RE: AUSTRALIAN MUSEUM - ALTERATIONS AND ADDITIONS  
SSD 9452

On 22 October 2018, the Department of Planning and Environment requested the Government Architect NSW (GANSW) provide an independent design review of the Australian Museum (AM) Alterations and Additions (SSD 9452). In conducting the review, GANSW has considered the EIS prepared by Ethos Urban, dated 4<sup>th</sup> October 2018 (including its appendices), as well as the advice previously provided to the proponent through the State Design Review Panel (SDRP) which is chaired by GANSW.

new opening to Parkes Farmer facade at ground level. opening height aligns with existing crystal hall opening adjacent (refer section). removed sandstone blocks to be reused internally

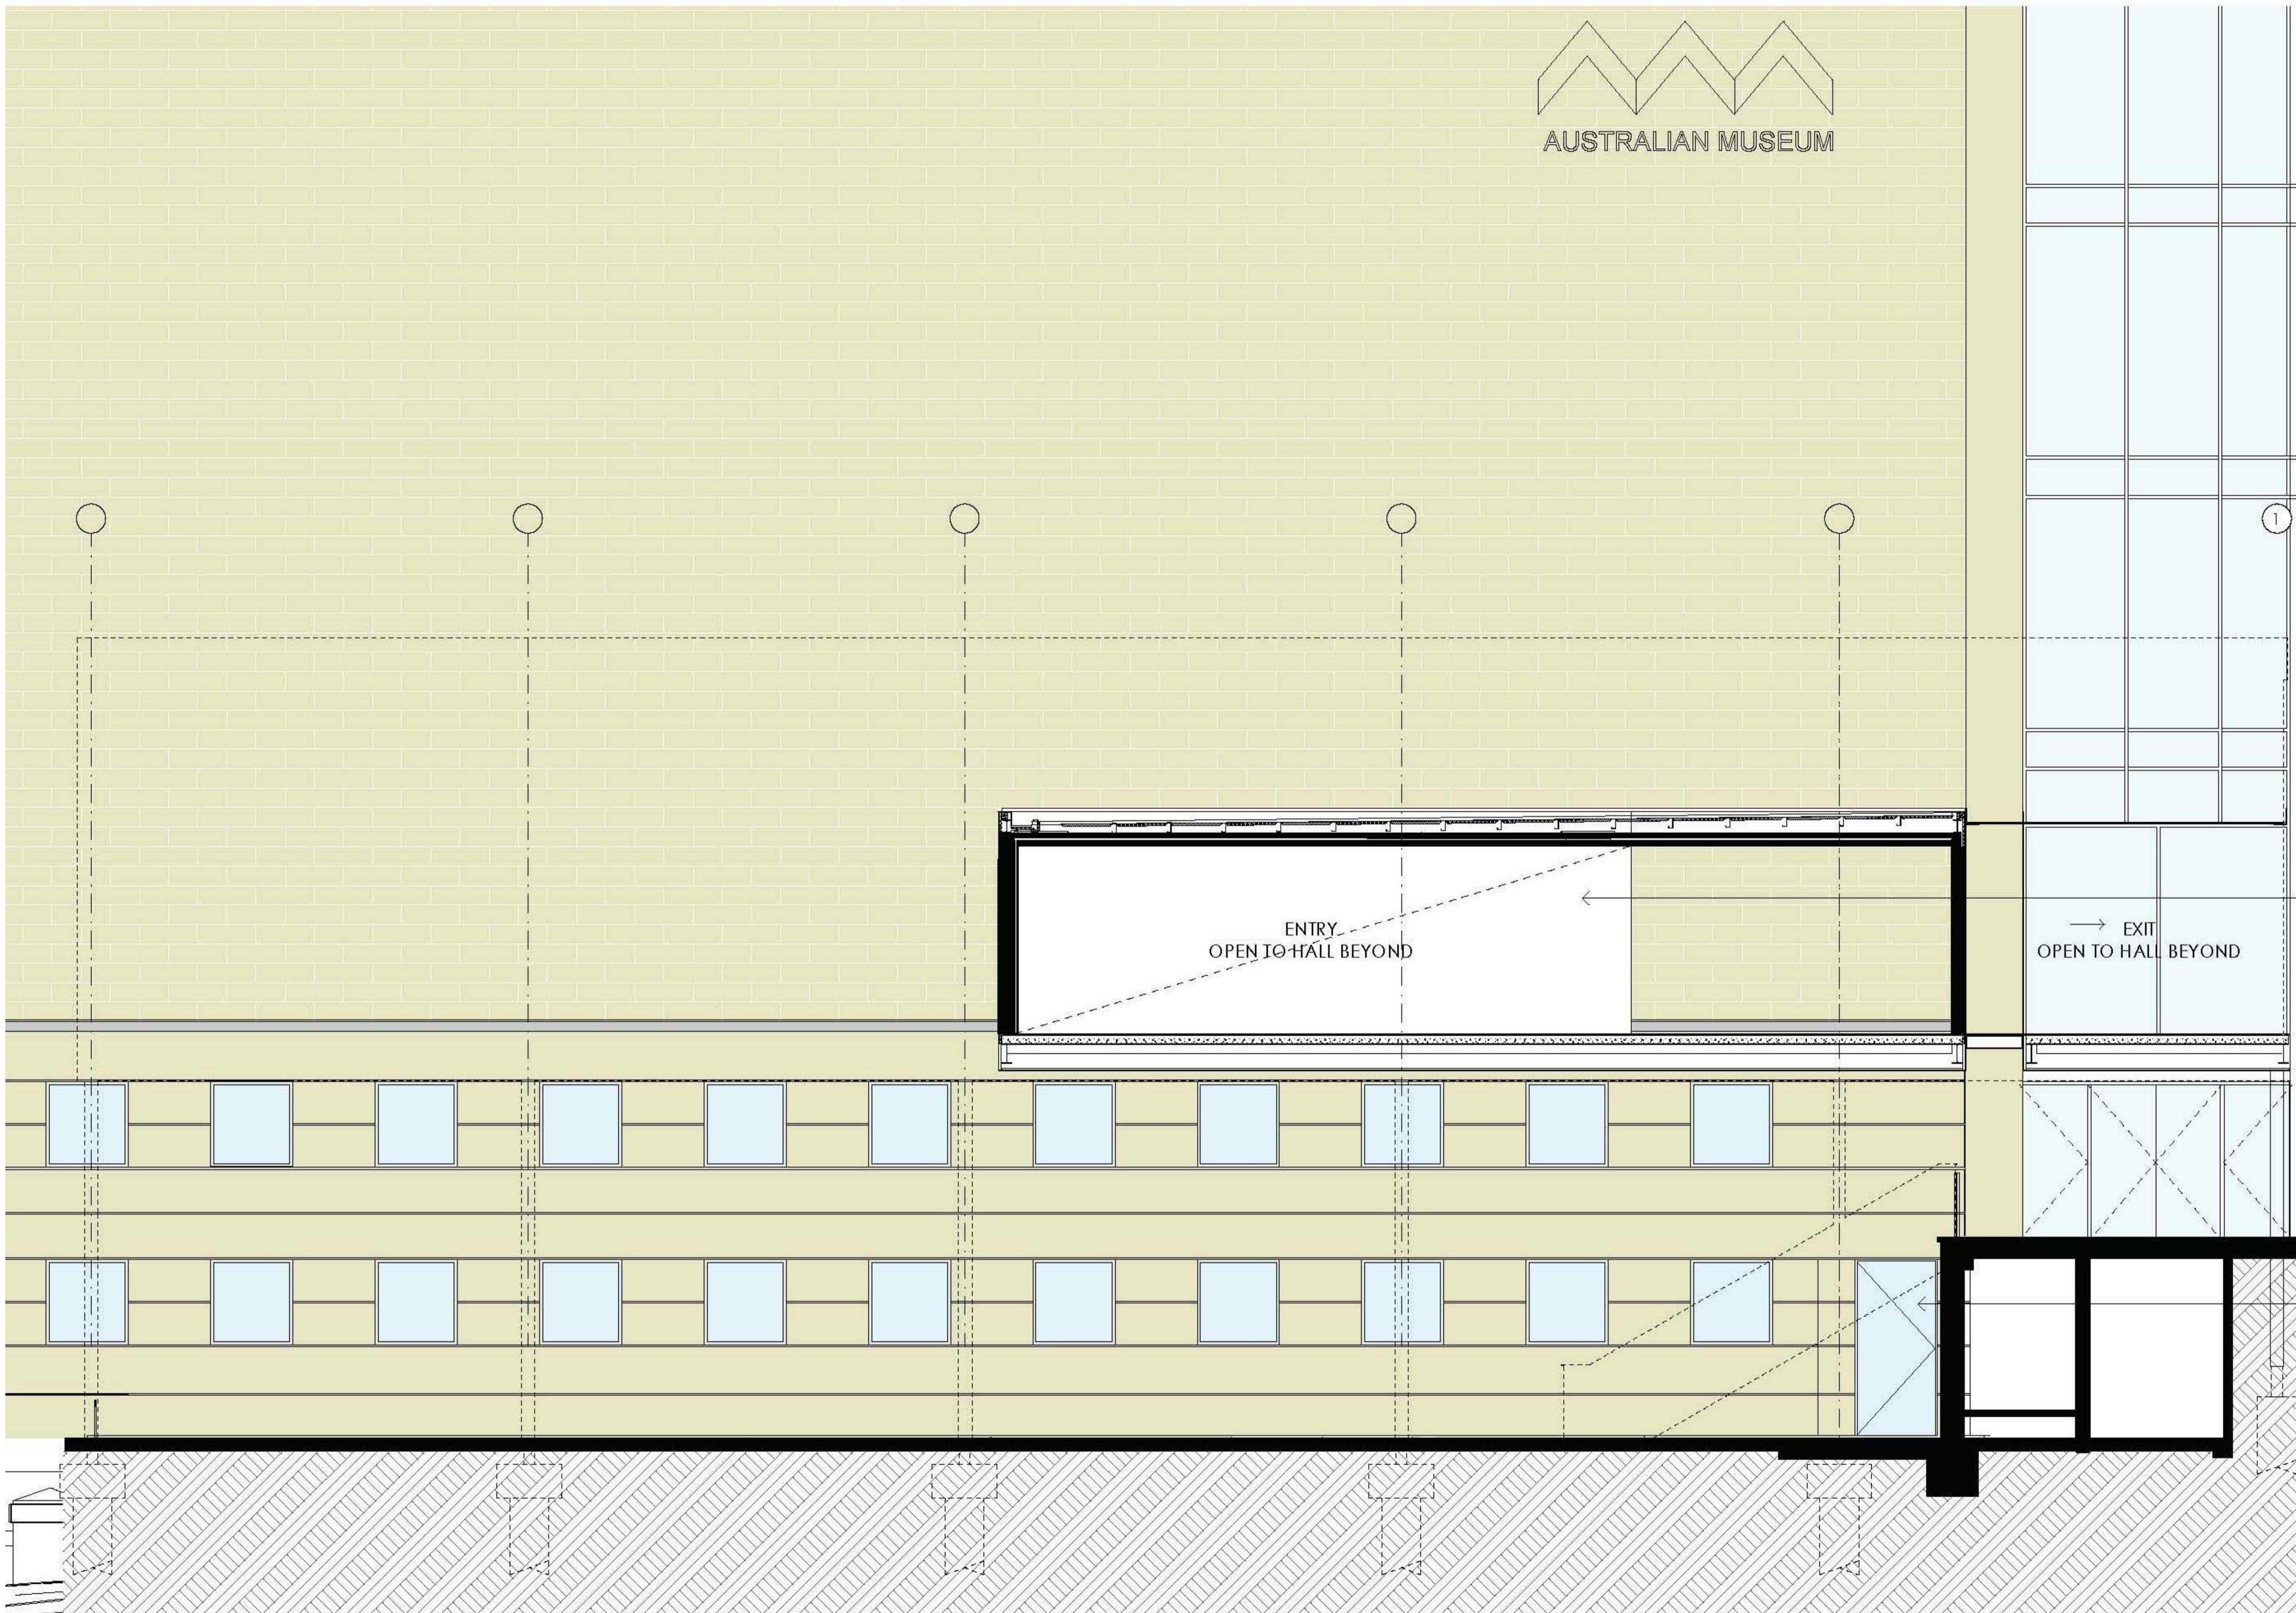
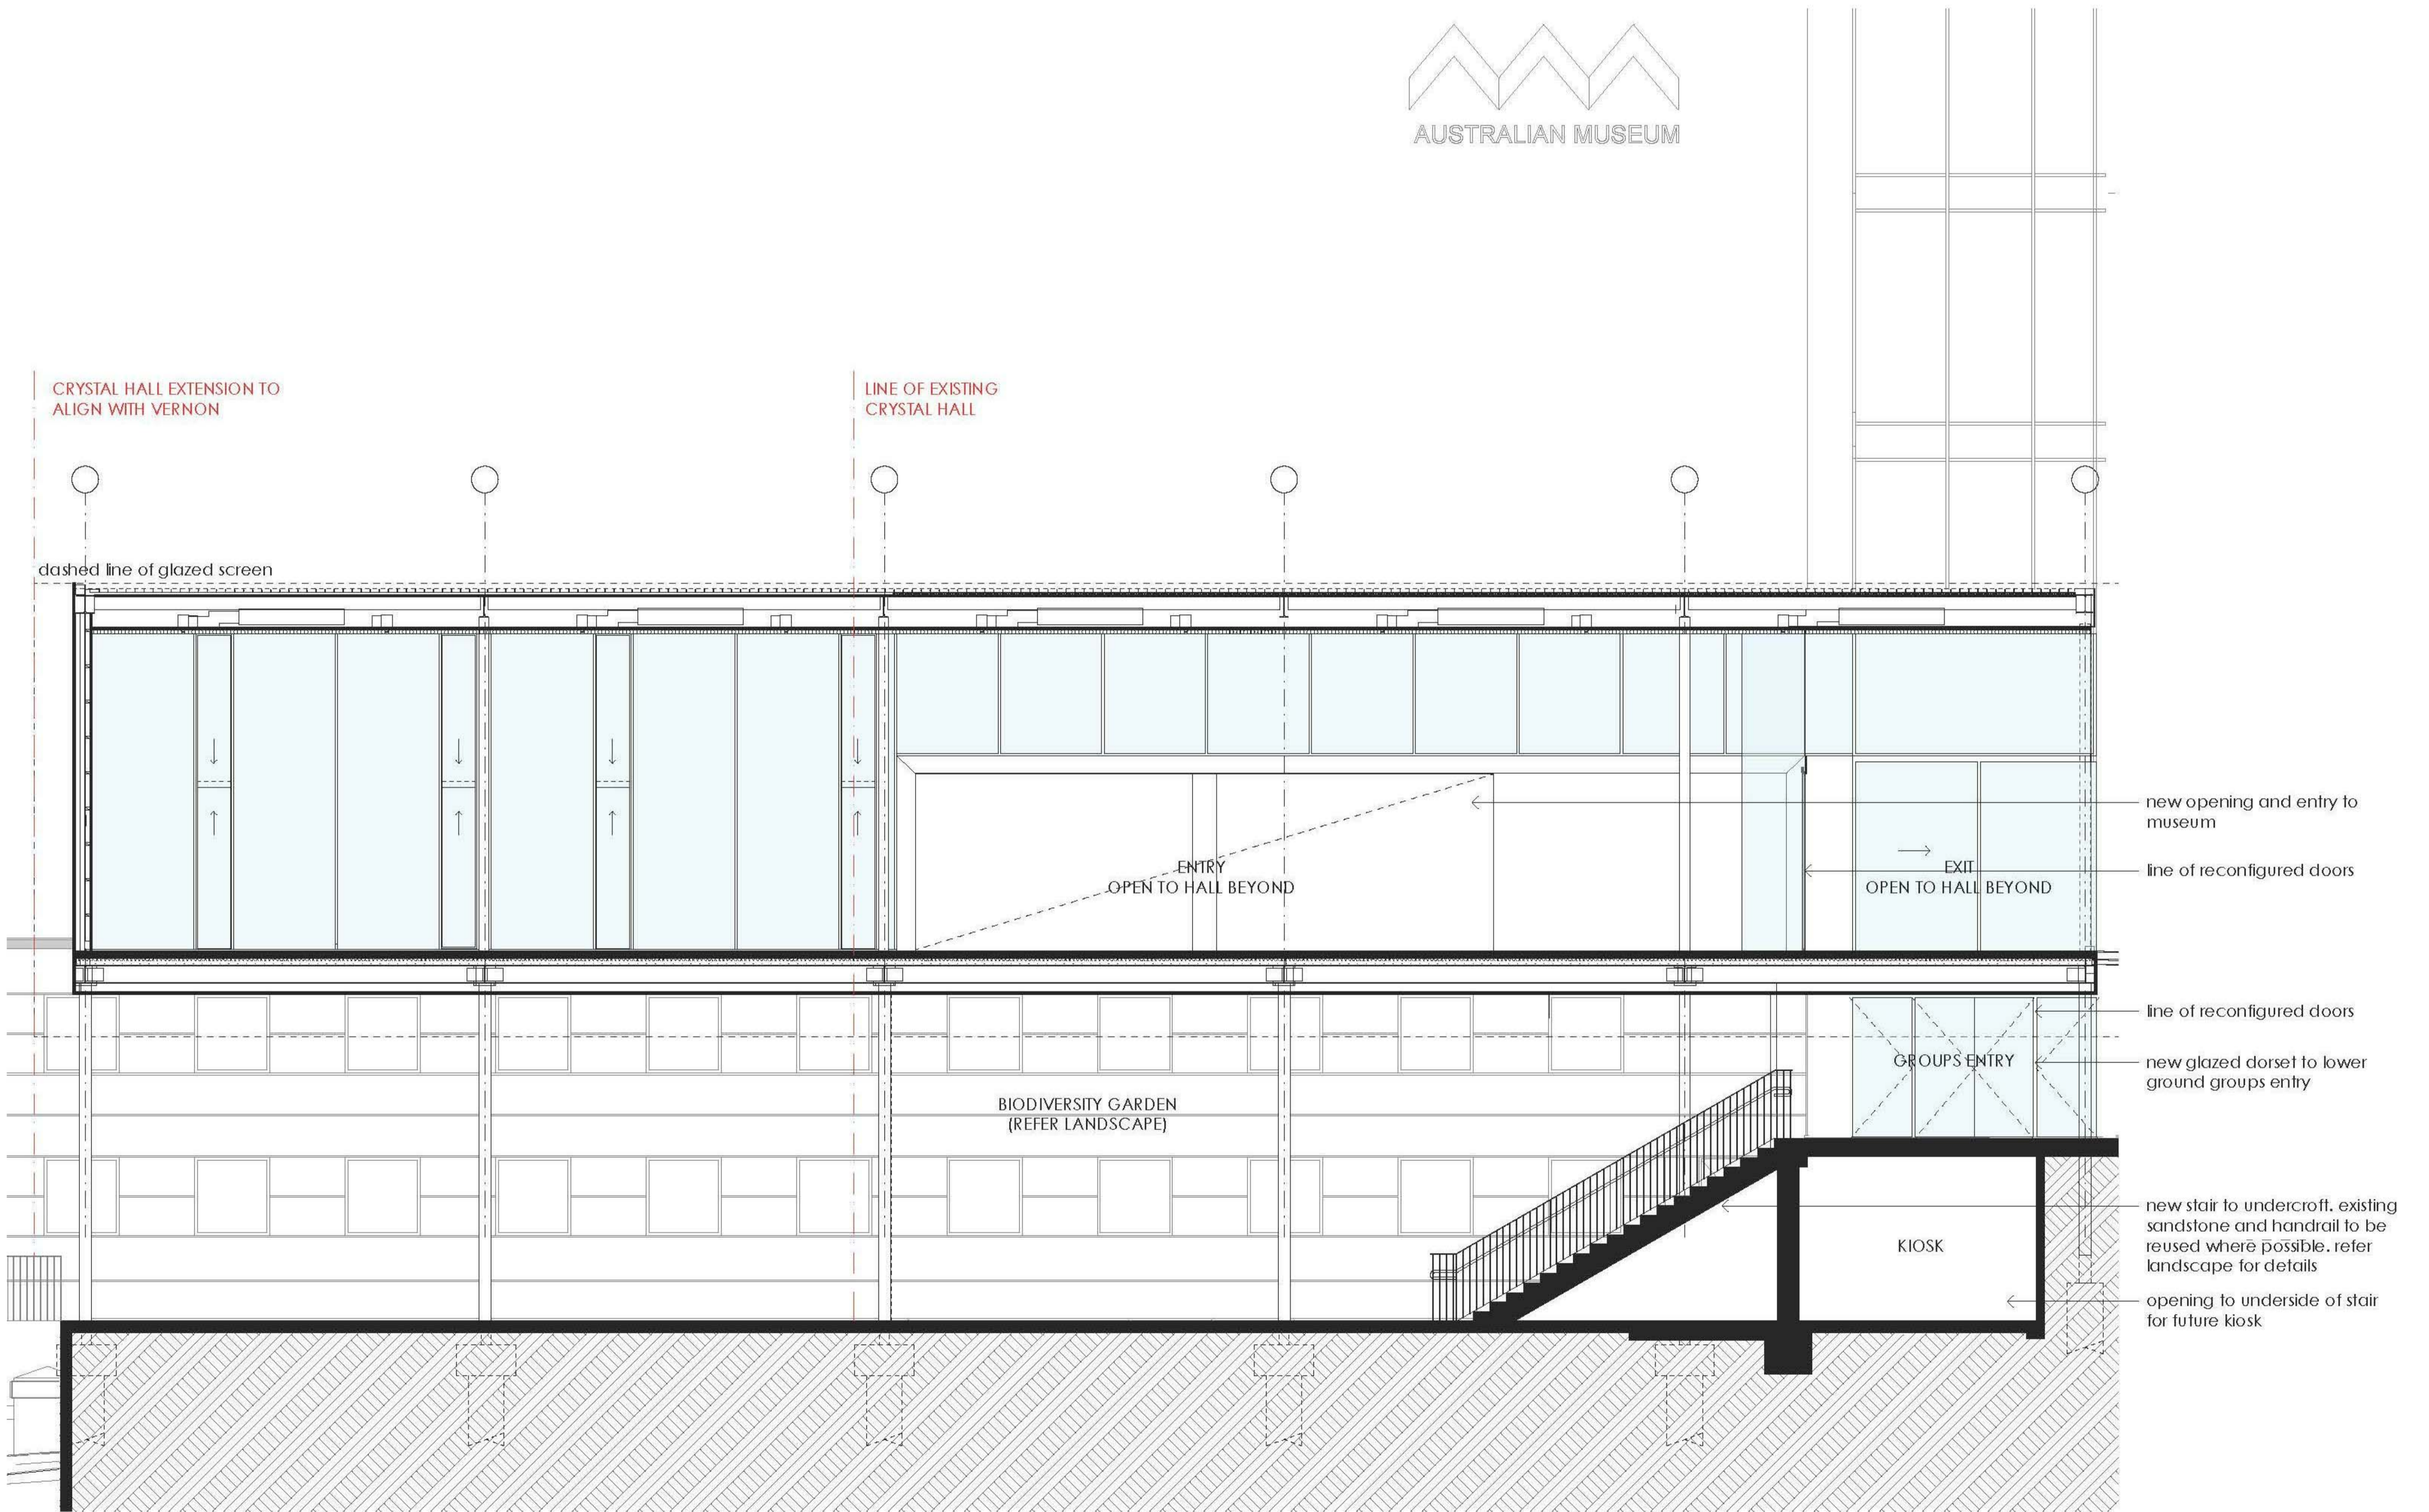
1. the new stair location;
2. the demolition of part of the sandstone façade to create a new door opening, disrupting the regular window pattern.

The proposed groups entry to William Street does not provide equitable access befitting its intended function (refer SDRP advice letter dated 20/09/18 p.3), nor demonstrate sufficient queuing space on the new outdoor stair landing. In the proposed scenario, group members that are unable to use the stairs, will be required to enter separately through the small new door to the basement level foyer in order to use the lift. However, in the plan drawing, compliant doorway clearances are not shown and the yellow shading indicating the ‘Public Foyer’ does not extend to the lift. Further information should be sought for the design of

this entry and foyer to ensure equitable access can be achieved alongside sensitive and respectful treatment of the heritage façade. This should include details of existing plant rooms in this area, options for relocating equipment and reconfiguring internal and external stairs, in order to achieve a suitable and consolidated secondary public groups entry at grade for the Museum.

Given the large public budget for the alterations and additions, the value of demolishing and rebuilding a new William Street stair should be reconsidered against the economic and social value of alternative options to create a new accessible level entry. We strongly recommend the design is developed to integrate with the existing architectural expression of the William Street façade, notably the glass infill façade between the Parkers Farmer and Lewis Wings.
